Grandview Reserve SKP

Resubmittal comment responses – August 17, 2020

EXISTING EX1

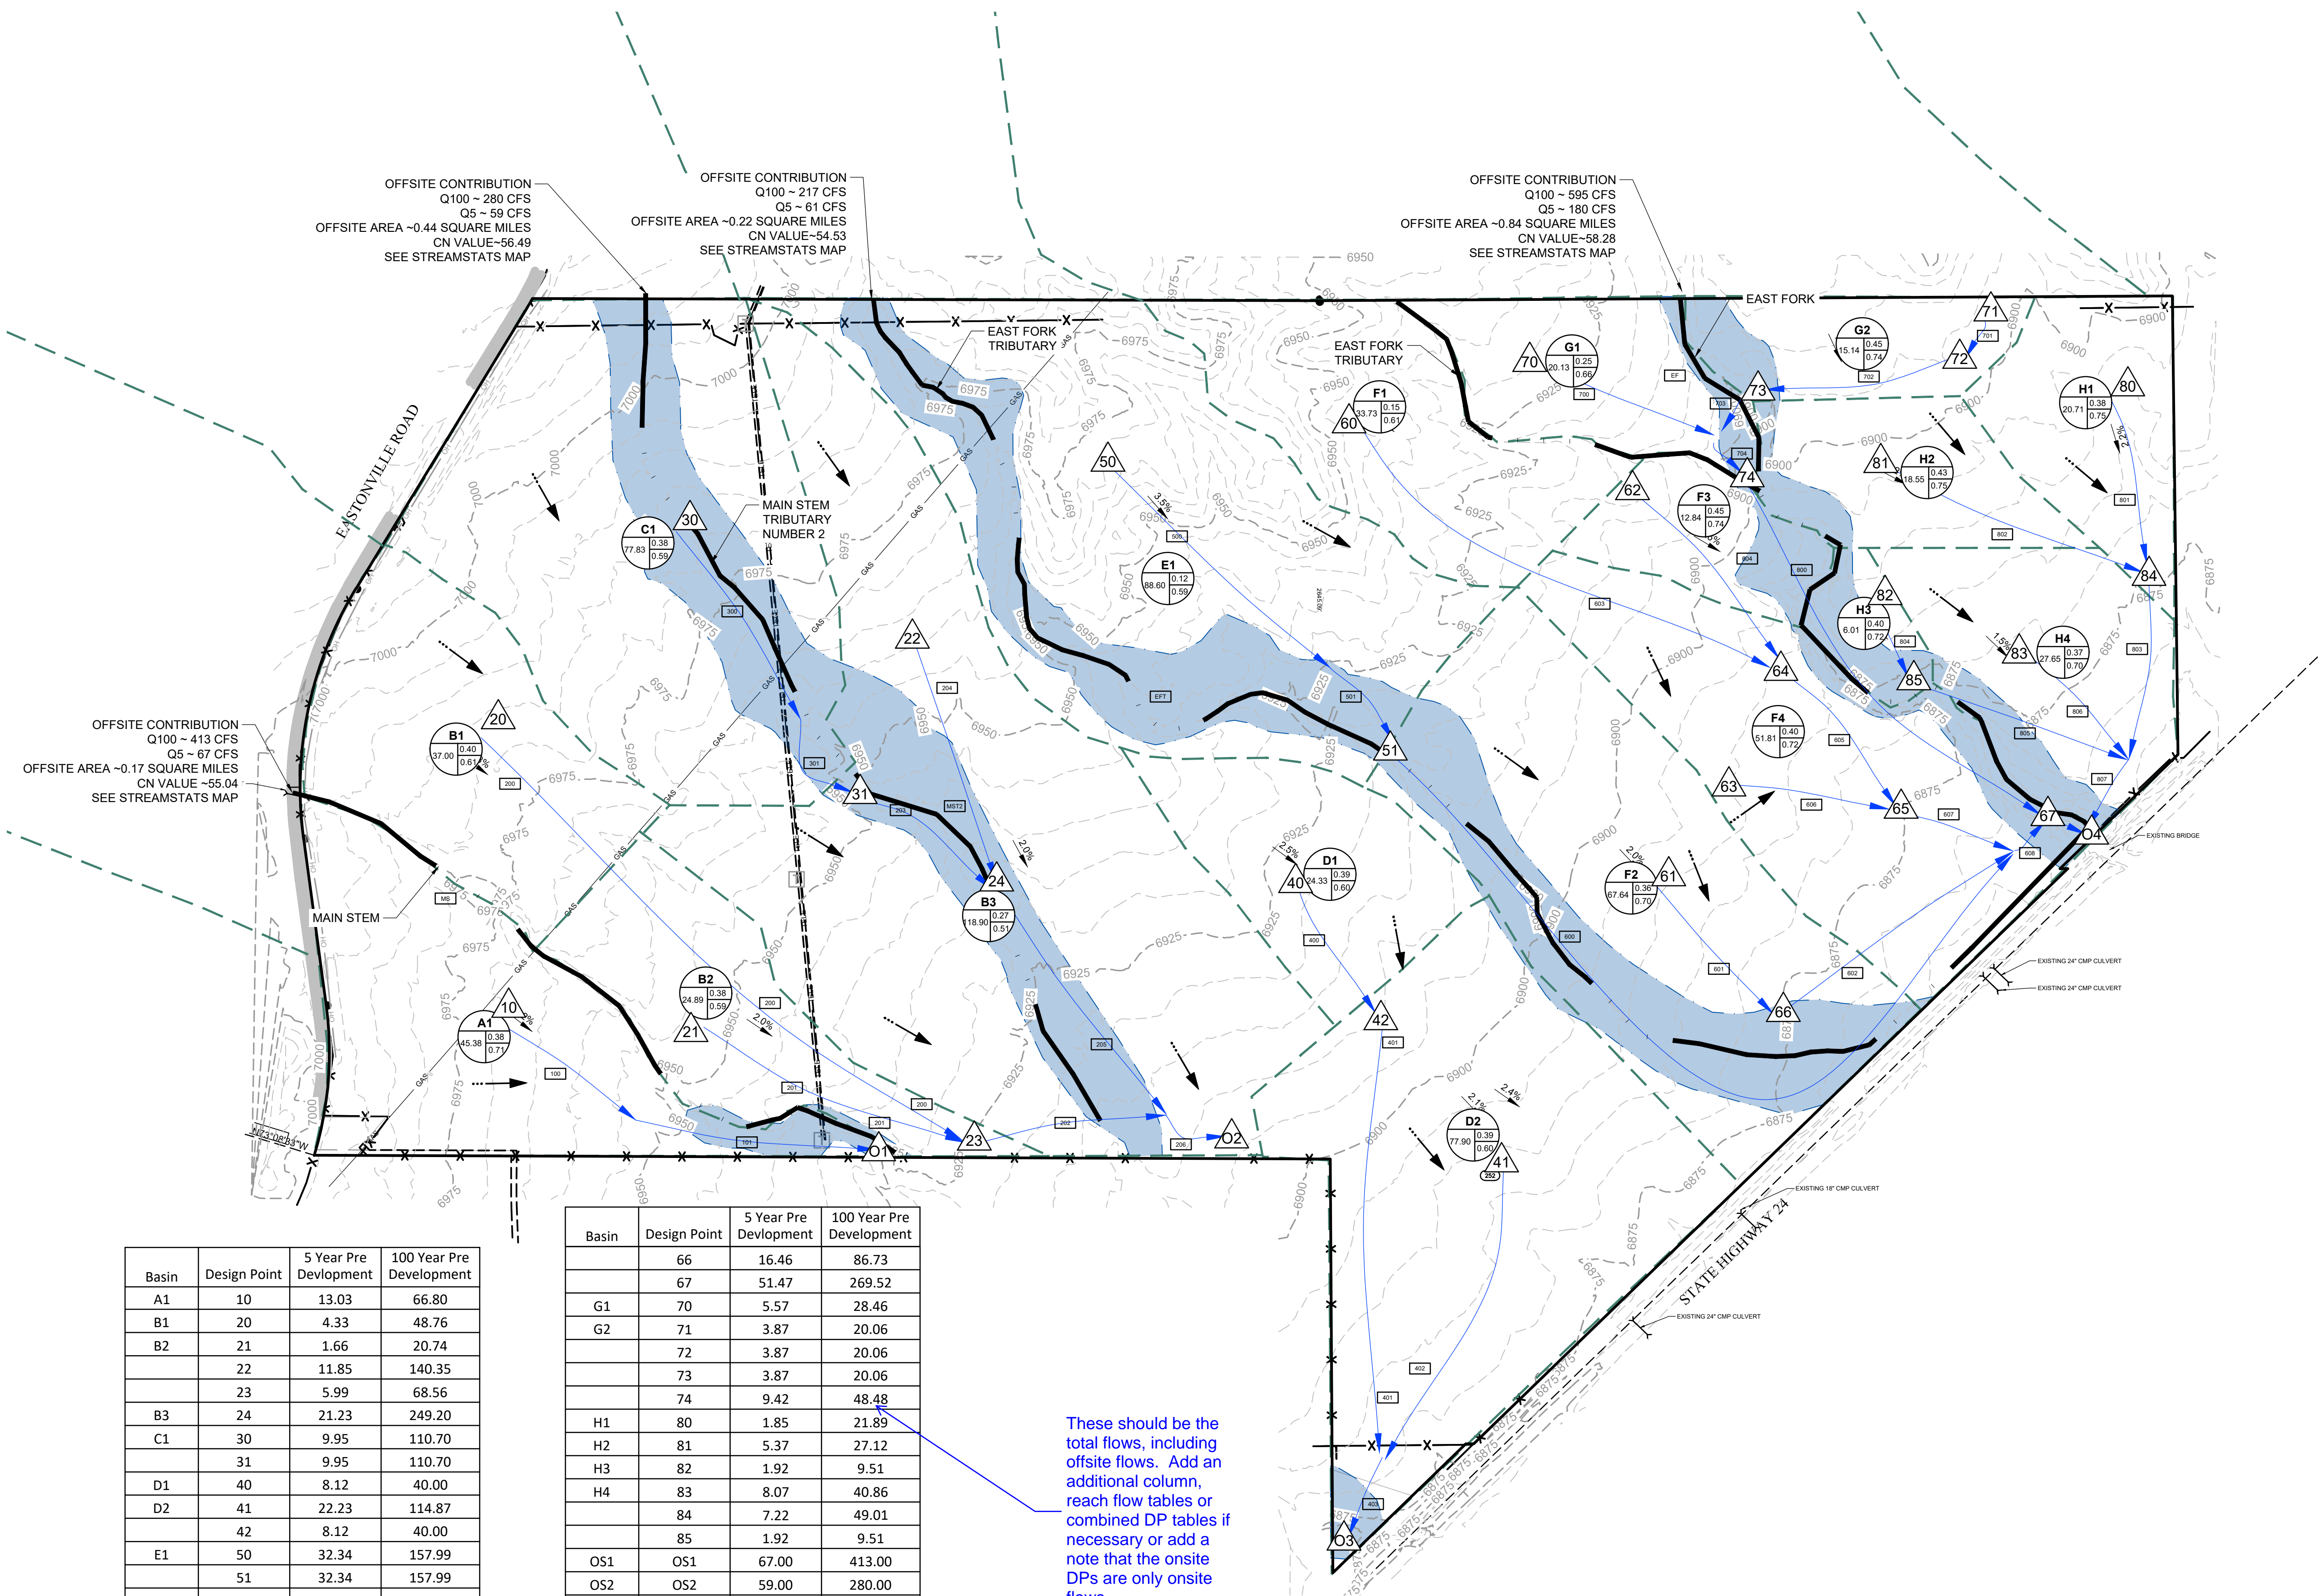
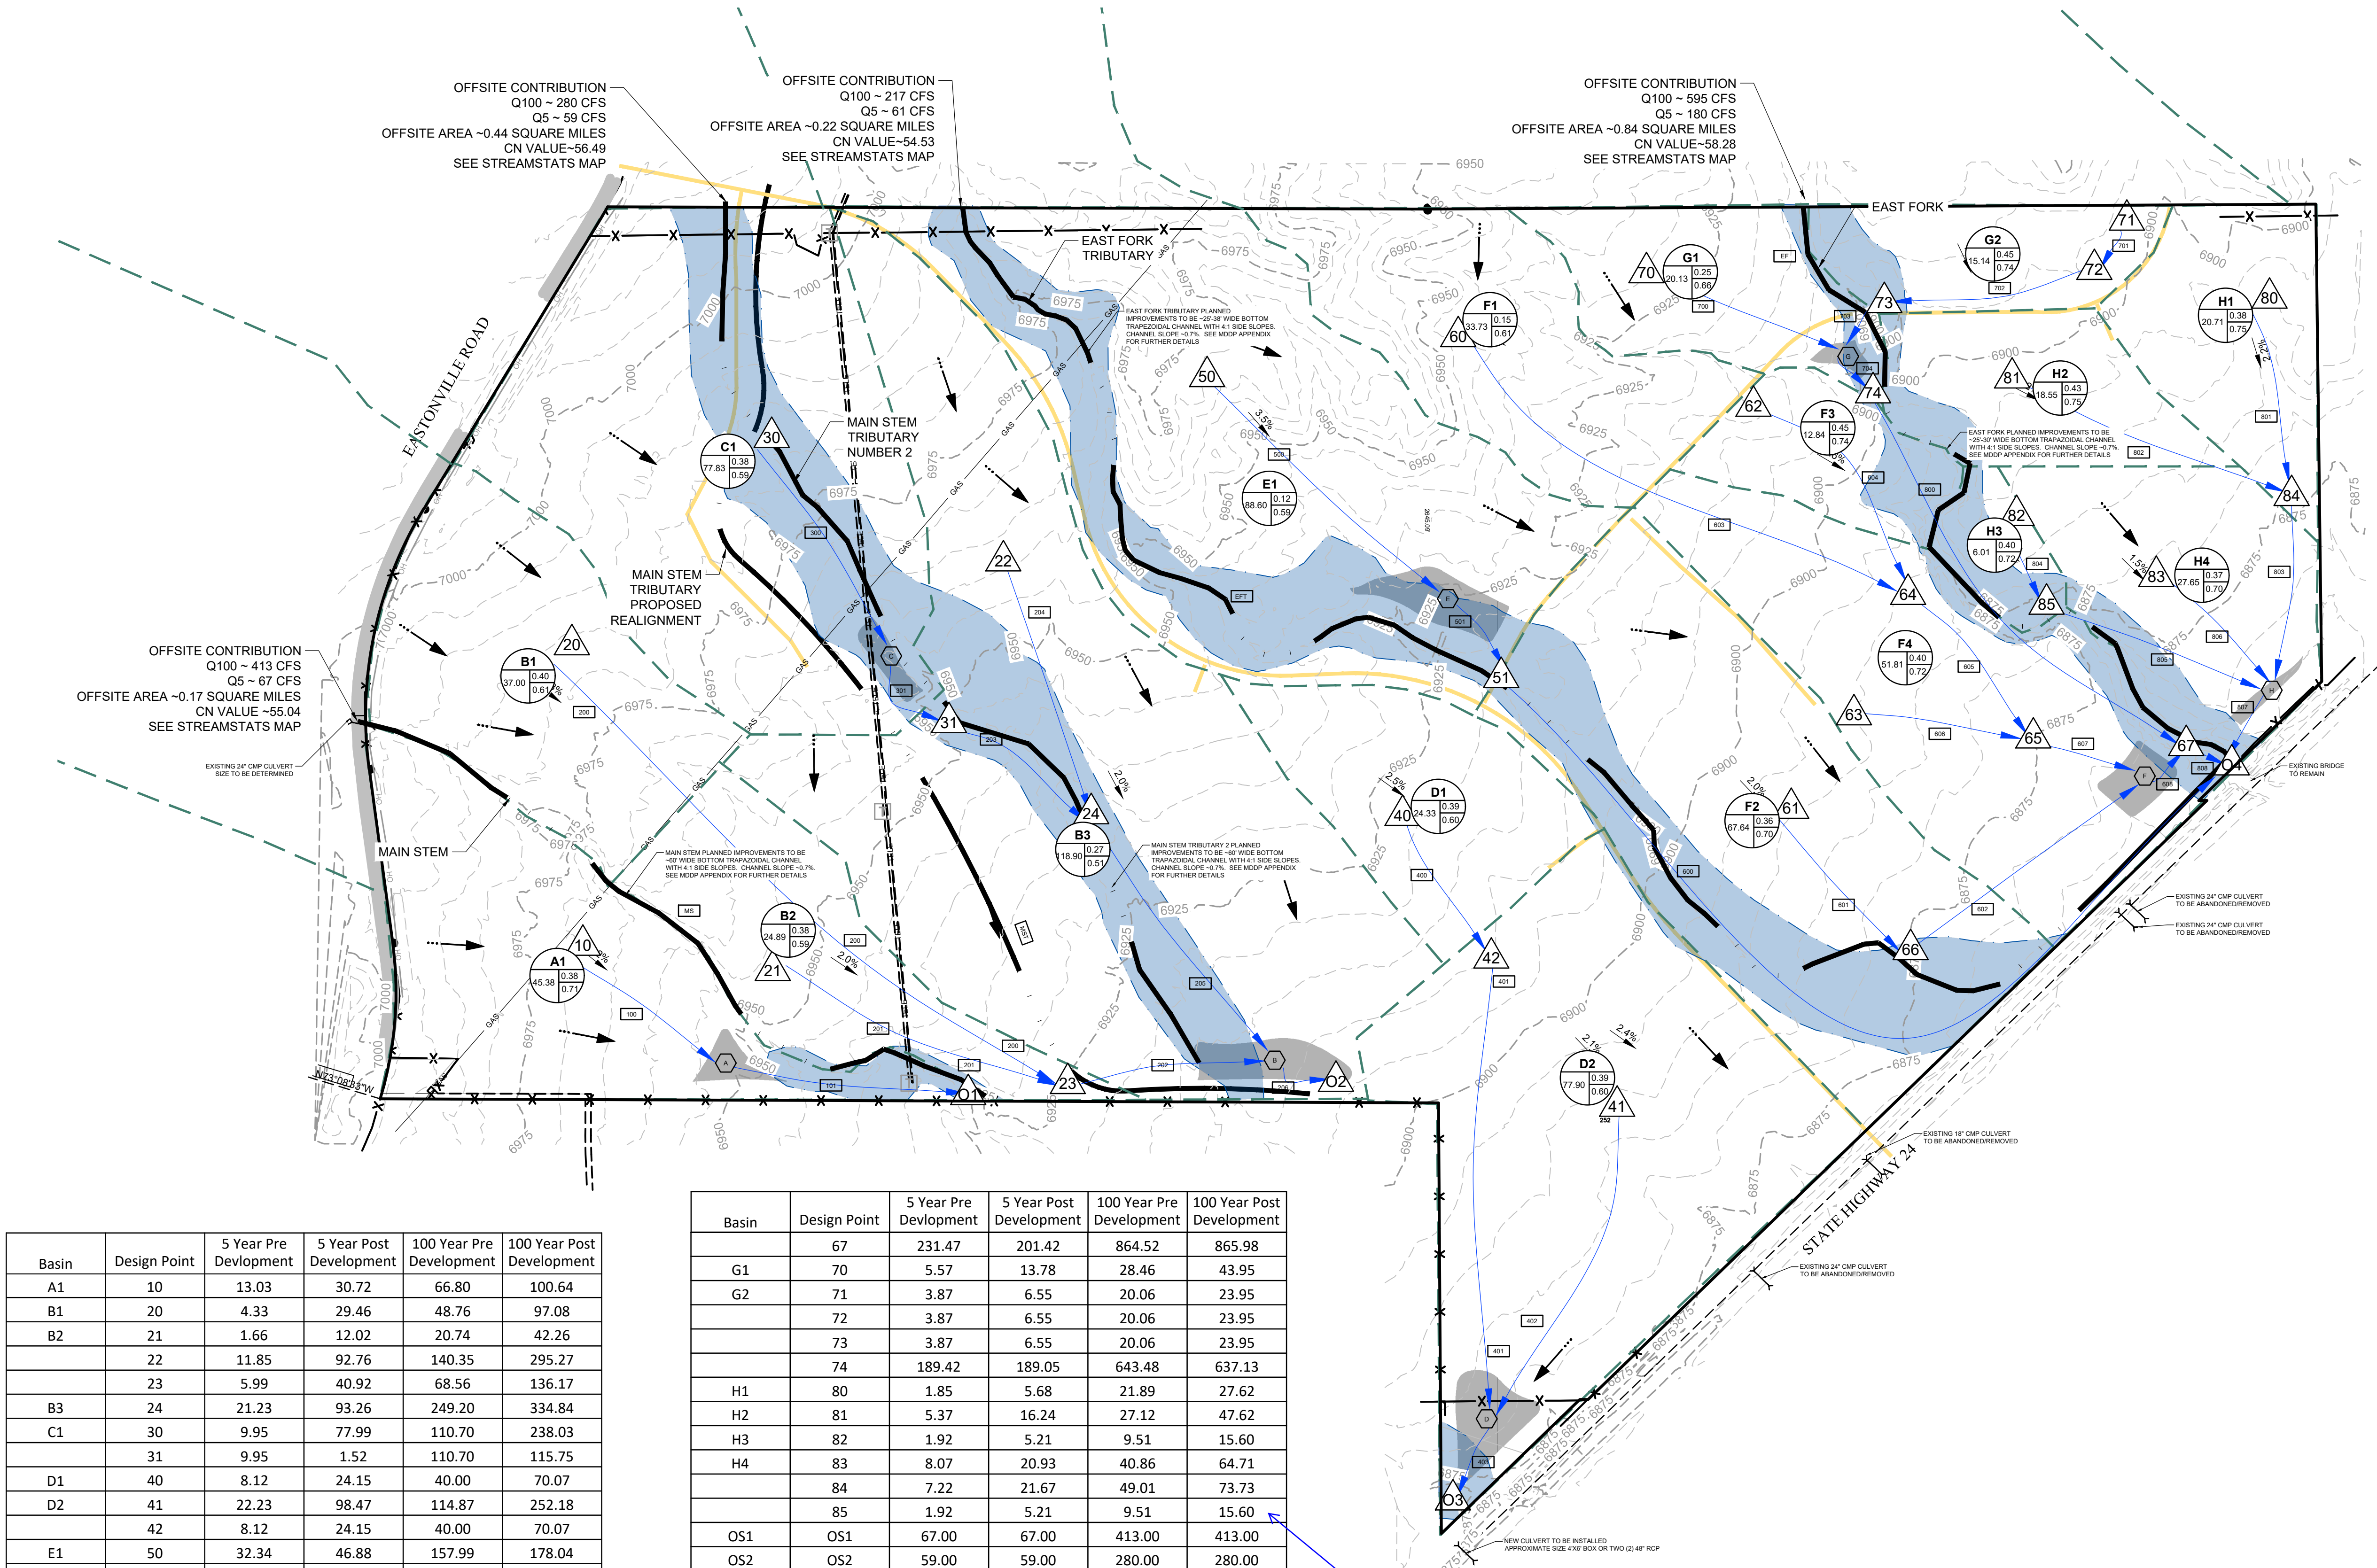
4. Address all offsite upstream basins and include their flows through the site. **Partially resolved; see redlines.**

5. **Resolved.**
6. Generally address interim and ultimate conditions where flows to and along Eastonville Road are potentially diverted (split flow) from intended/original locations until roadway drainage improvements (appropriate culvert sizes) are complete. It appears that upstream split flows will affect which channels receive the flow quantities previously assumed in the FEMA studies. **Partially resolved; see minor redlines. Future reports will need to reconcile diversions and flows used in previous studies.**

Response: Noted, redlines have been addressed. The map has been revised to show contours upgradient from the site.

Response: Noted, redlines have been addressed.
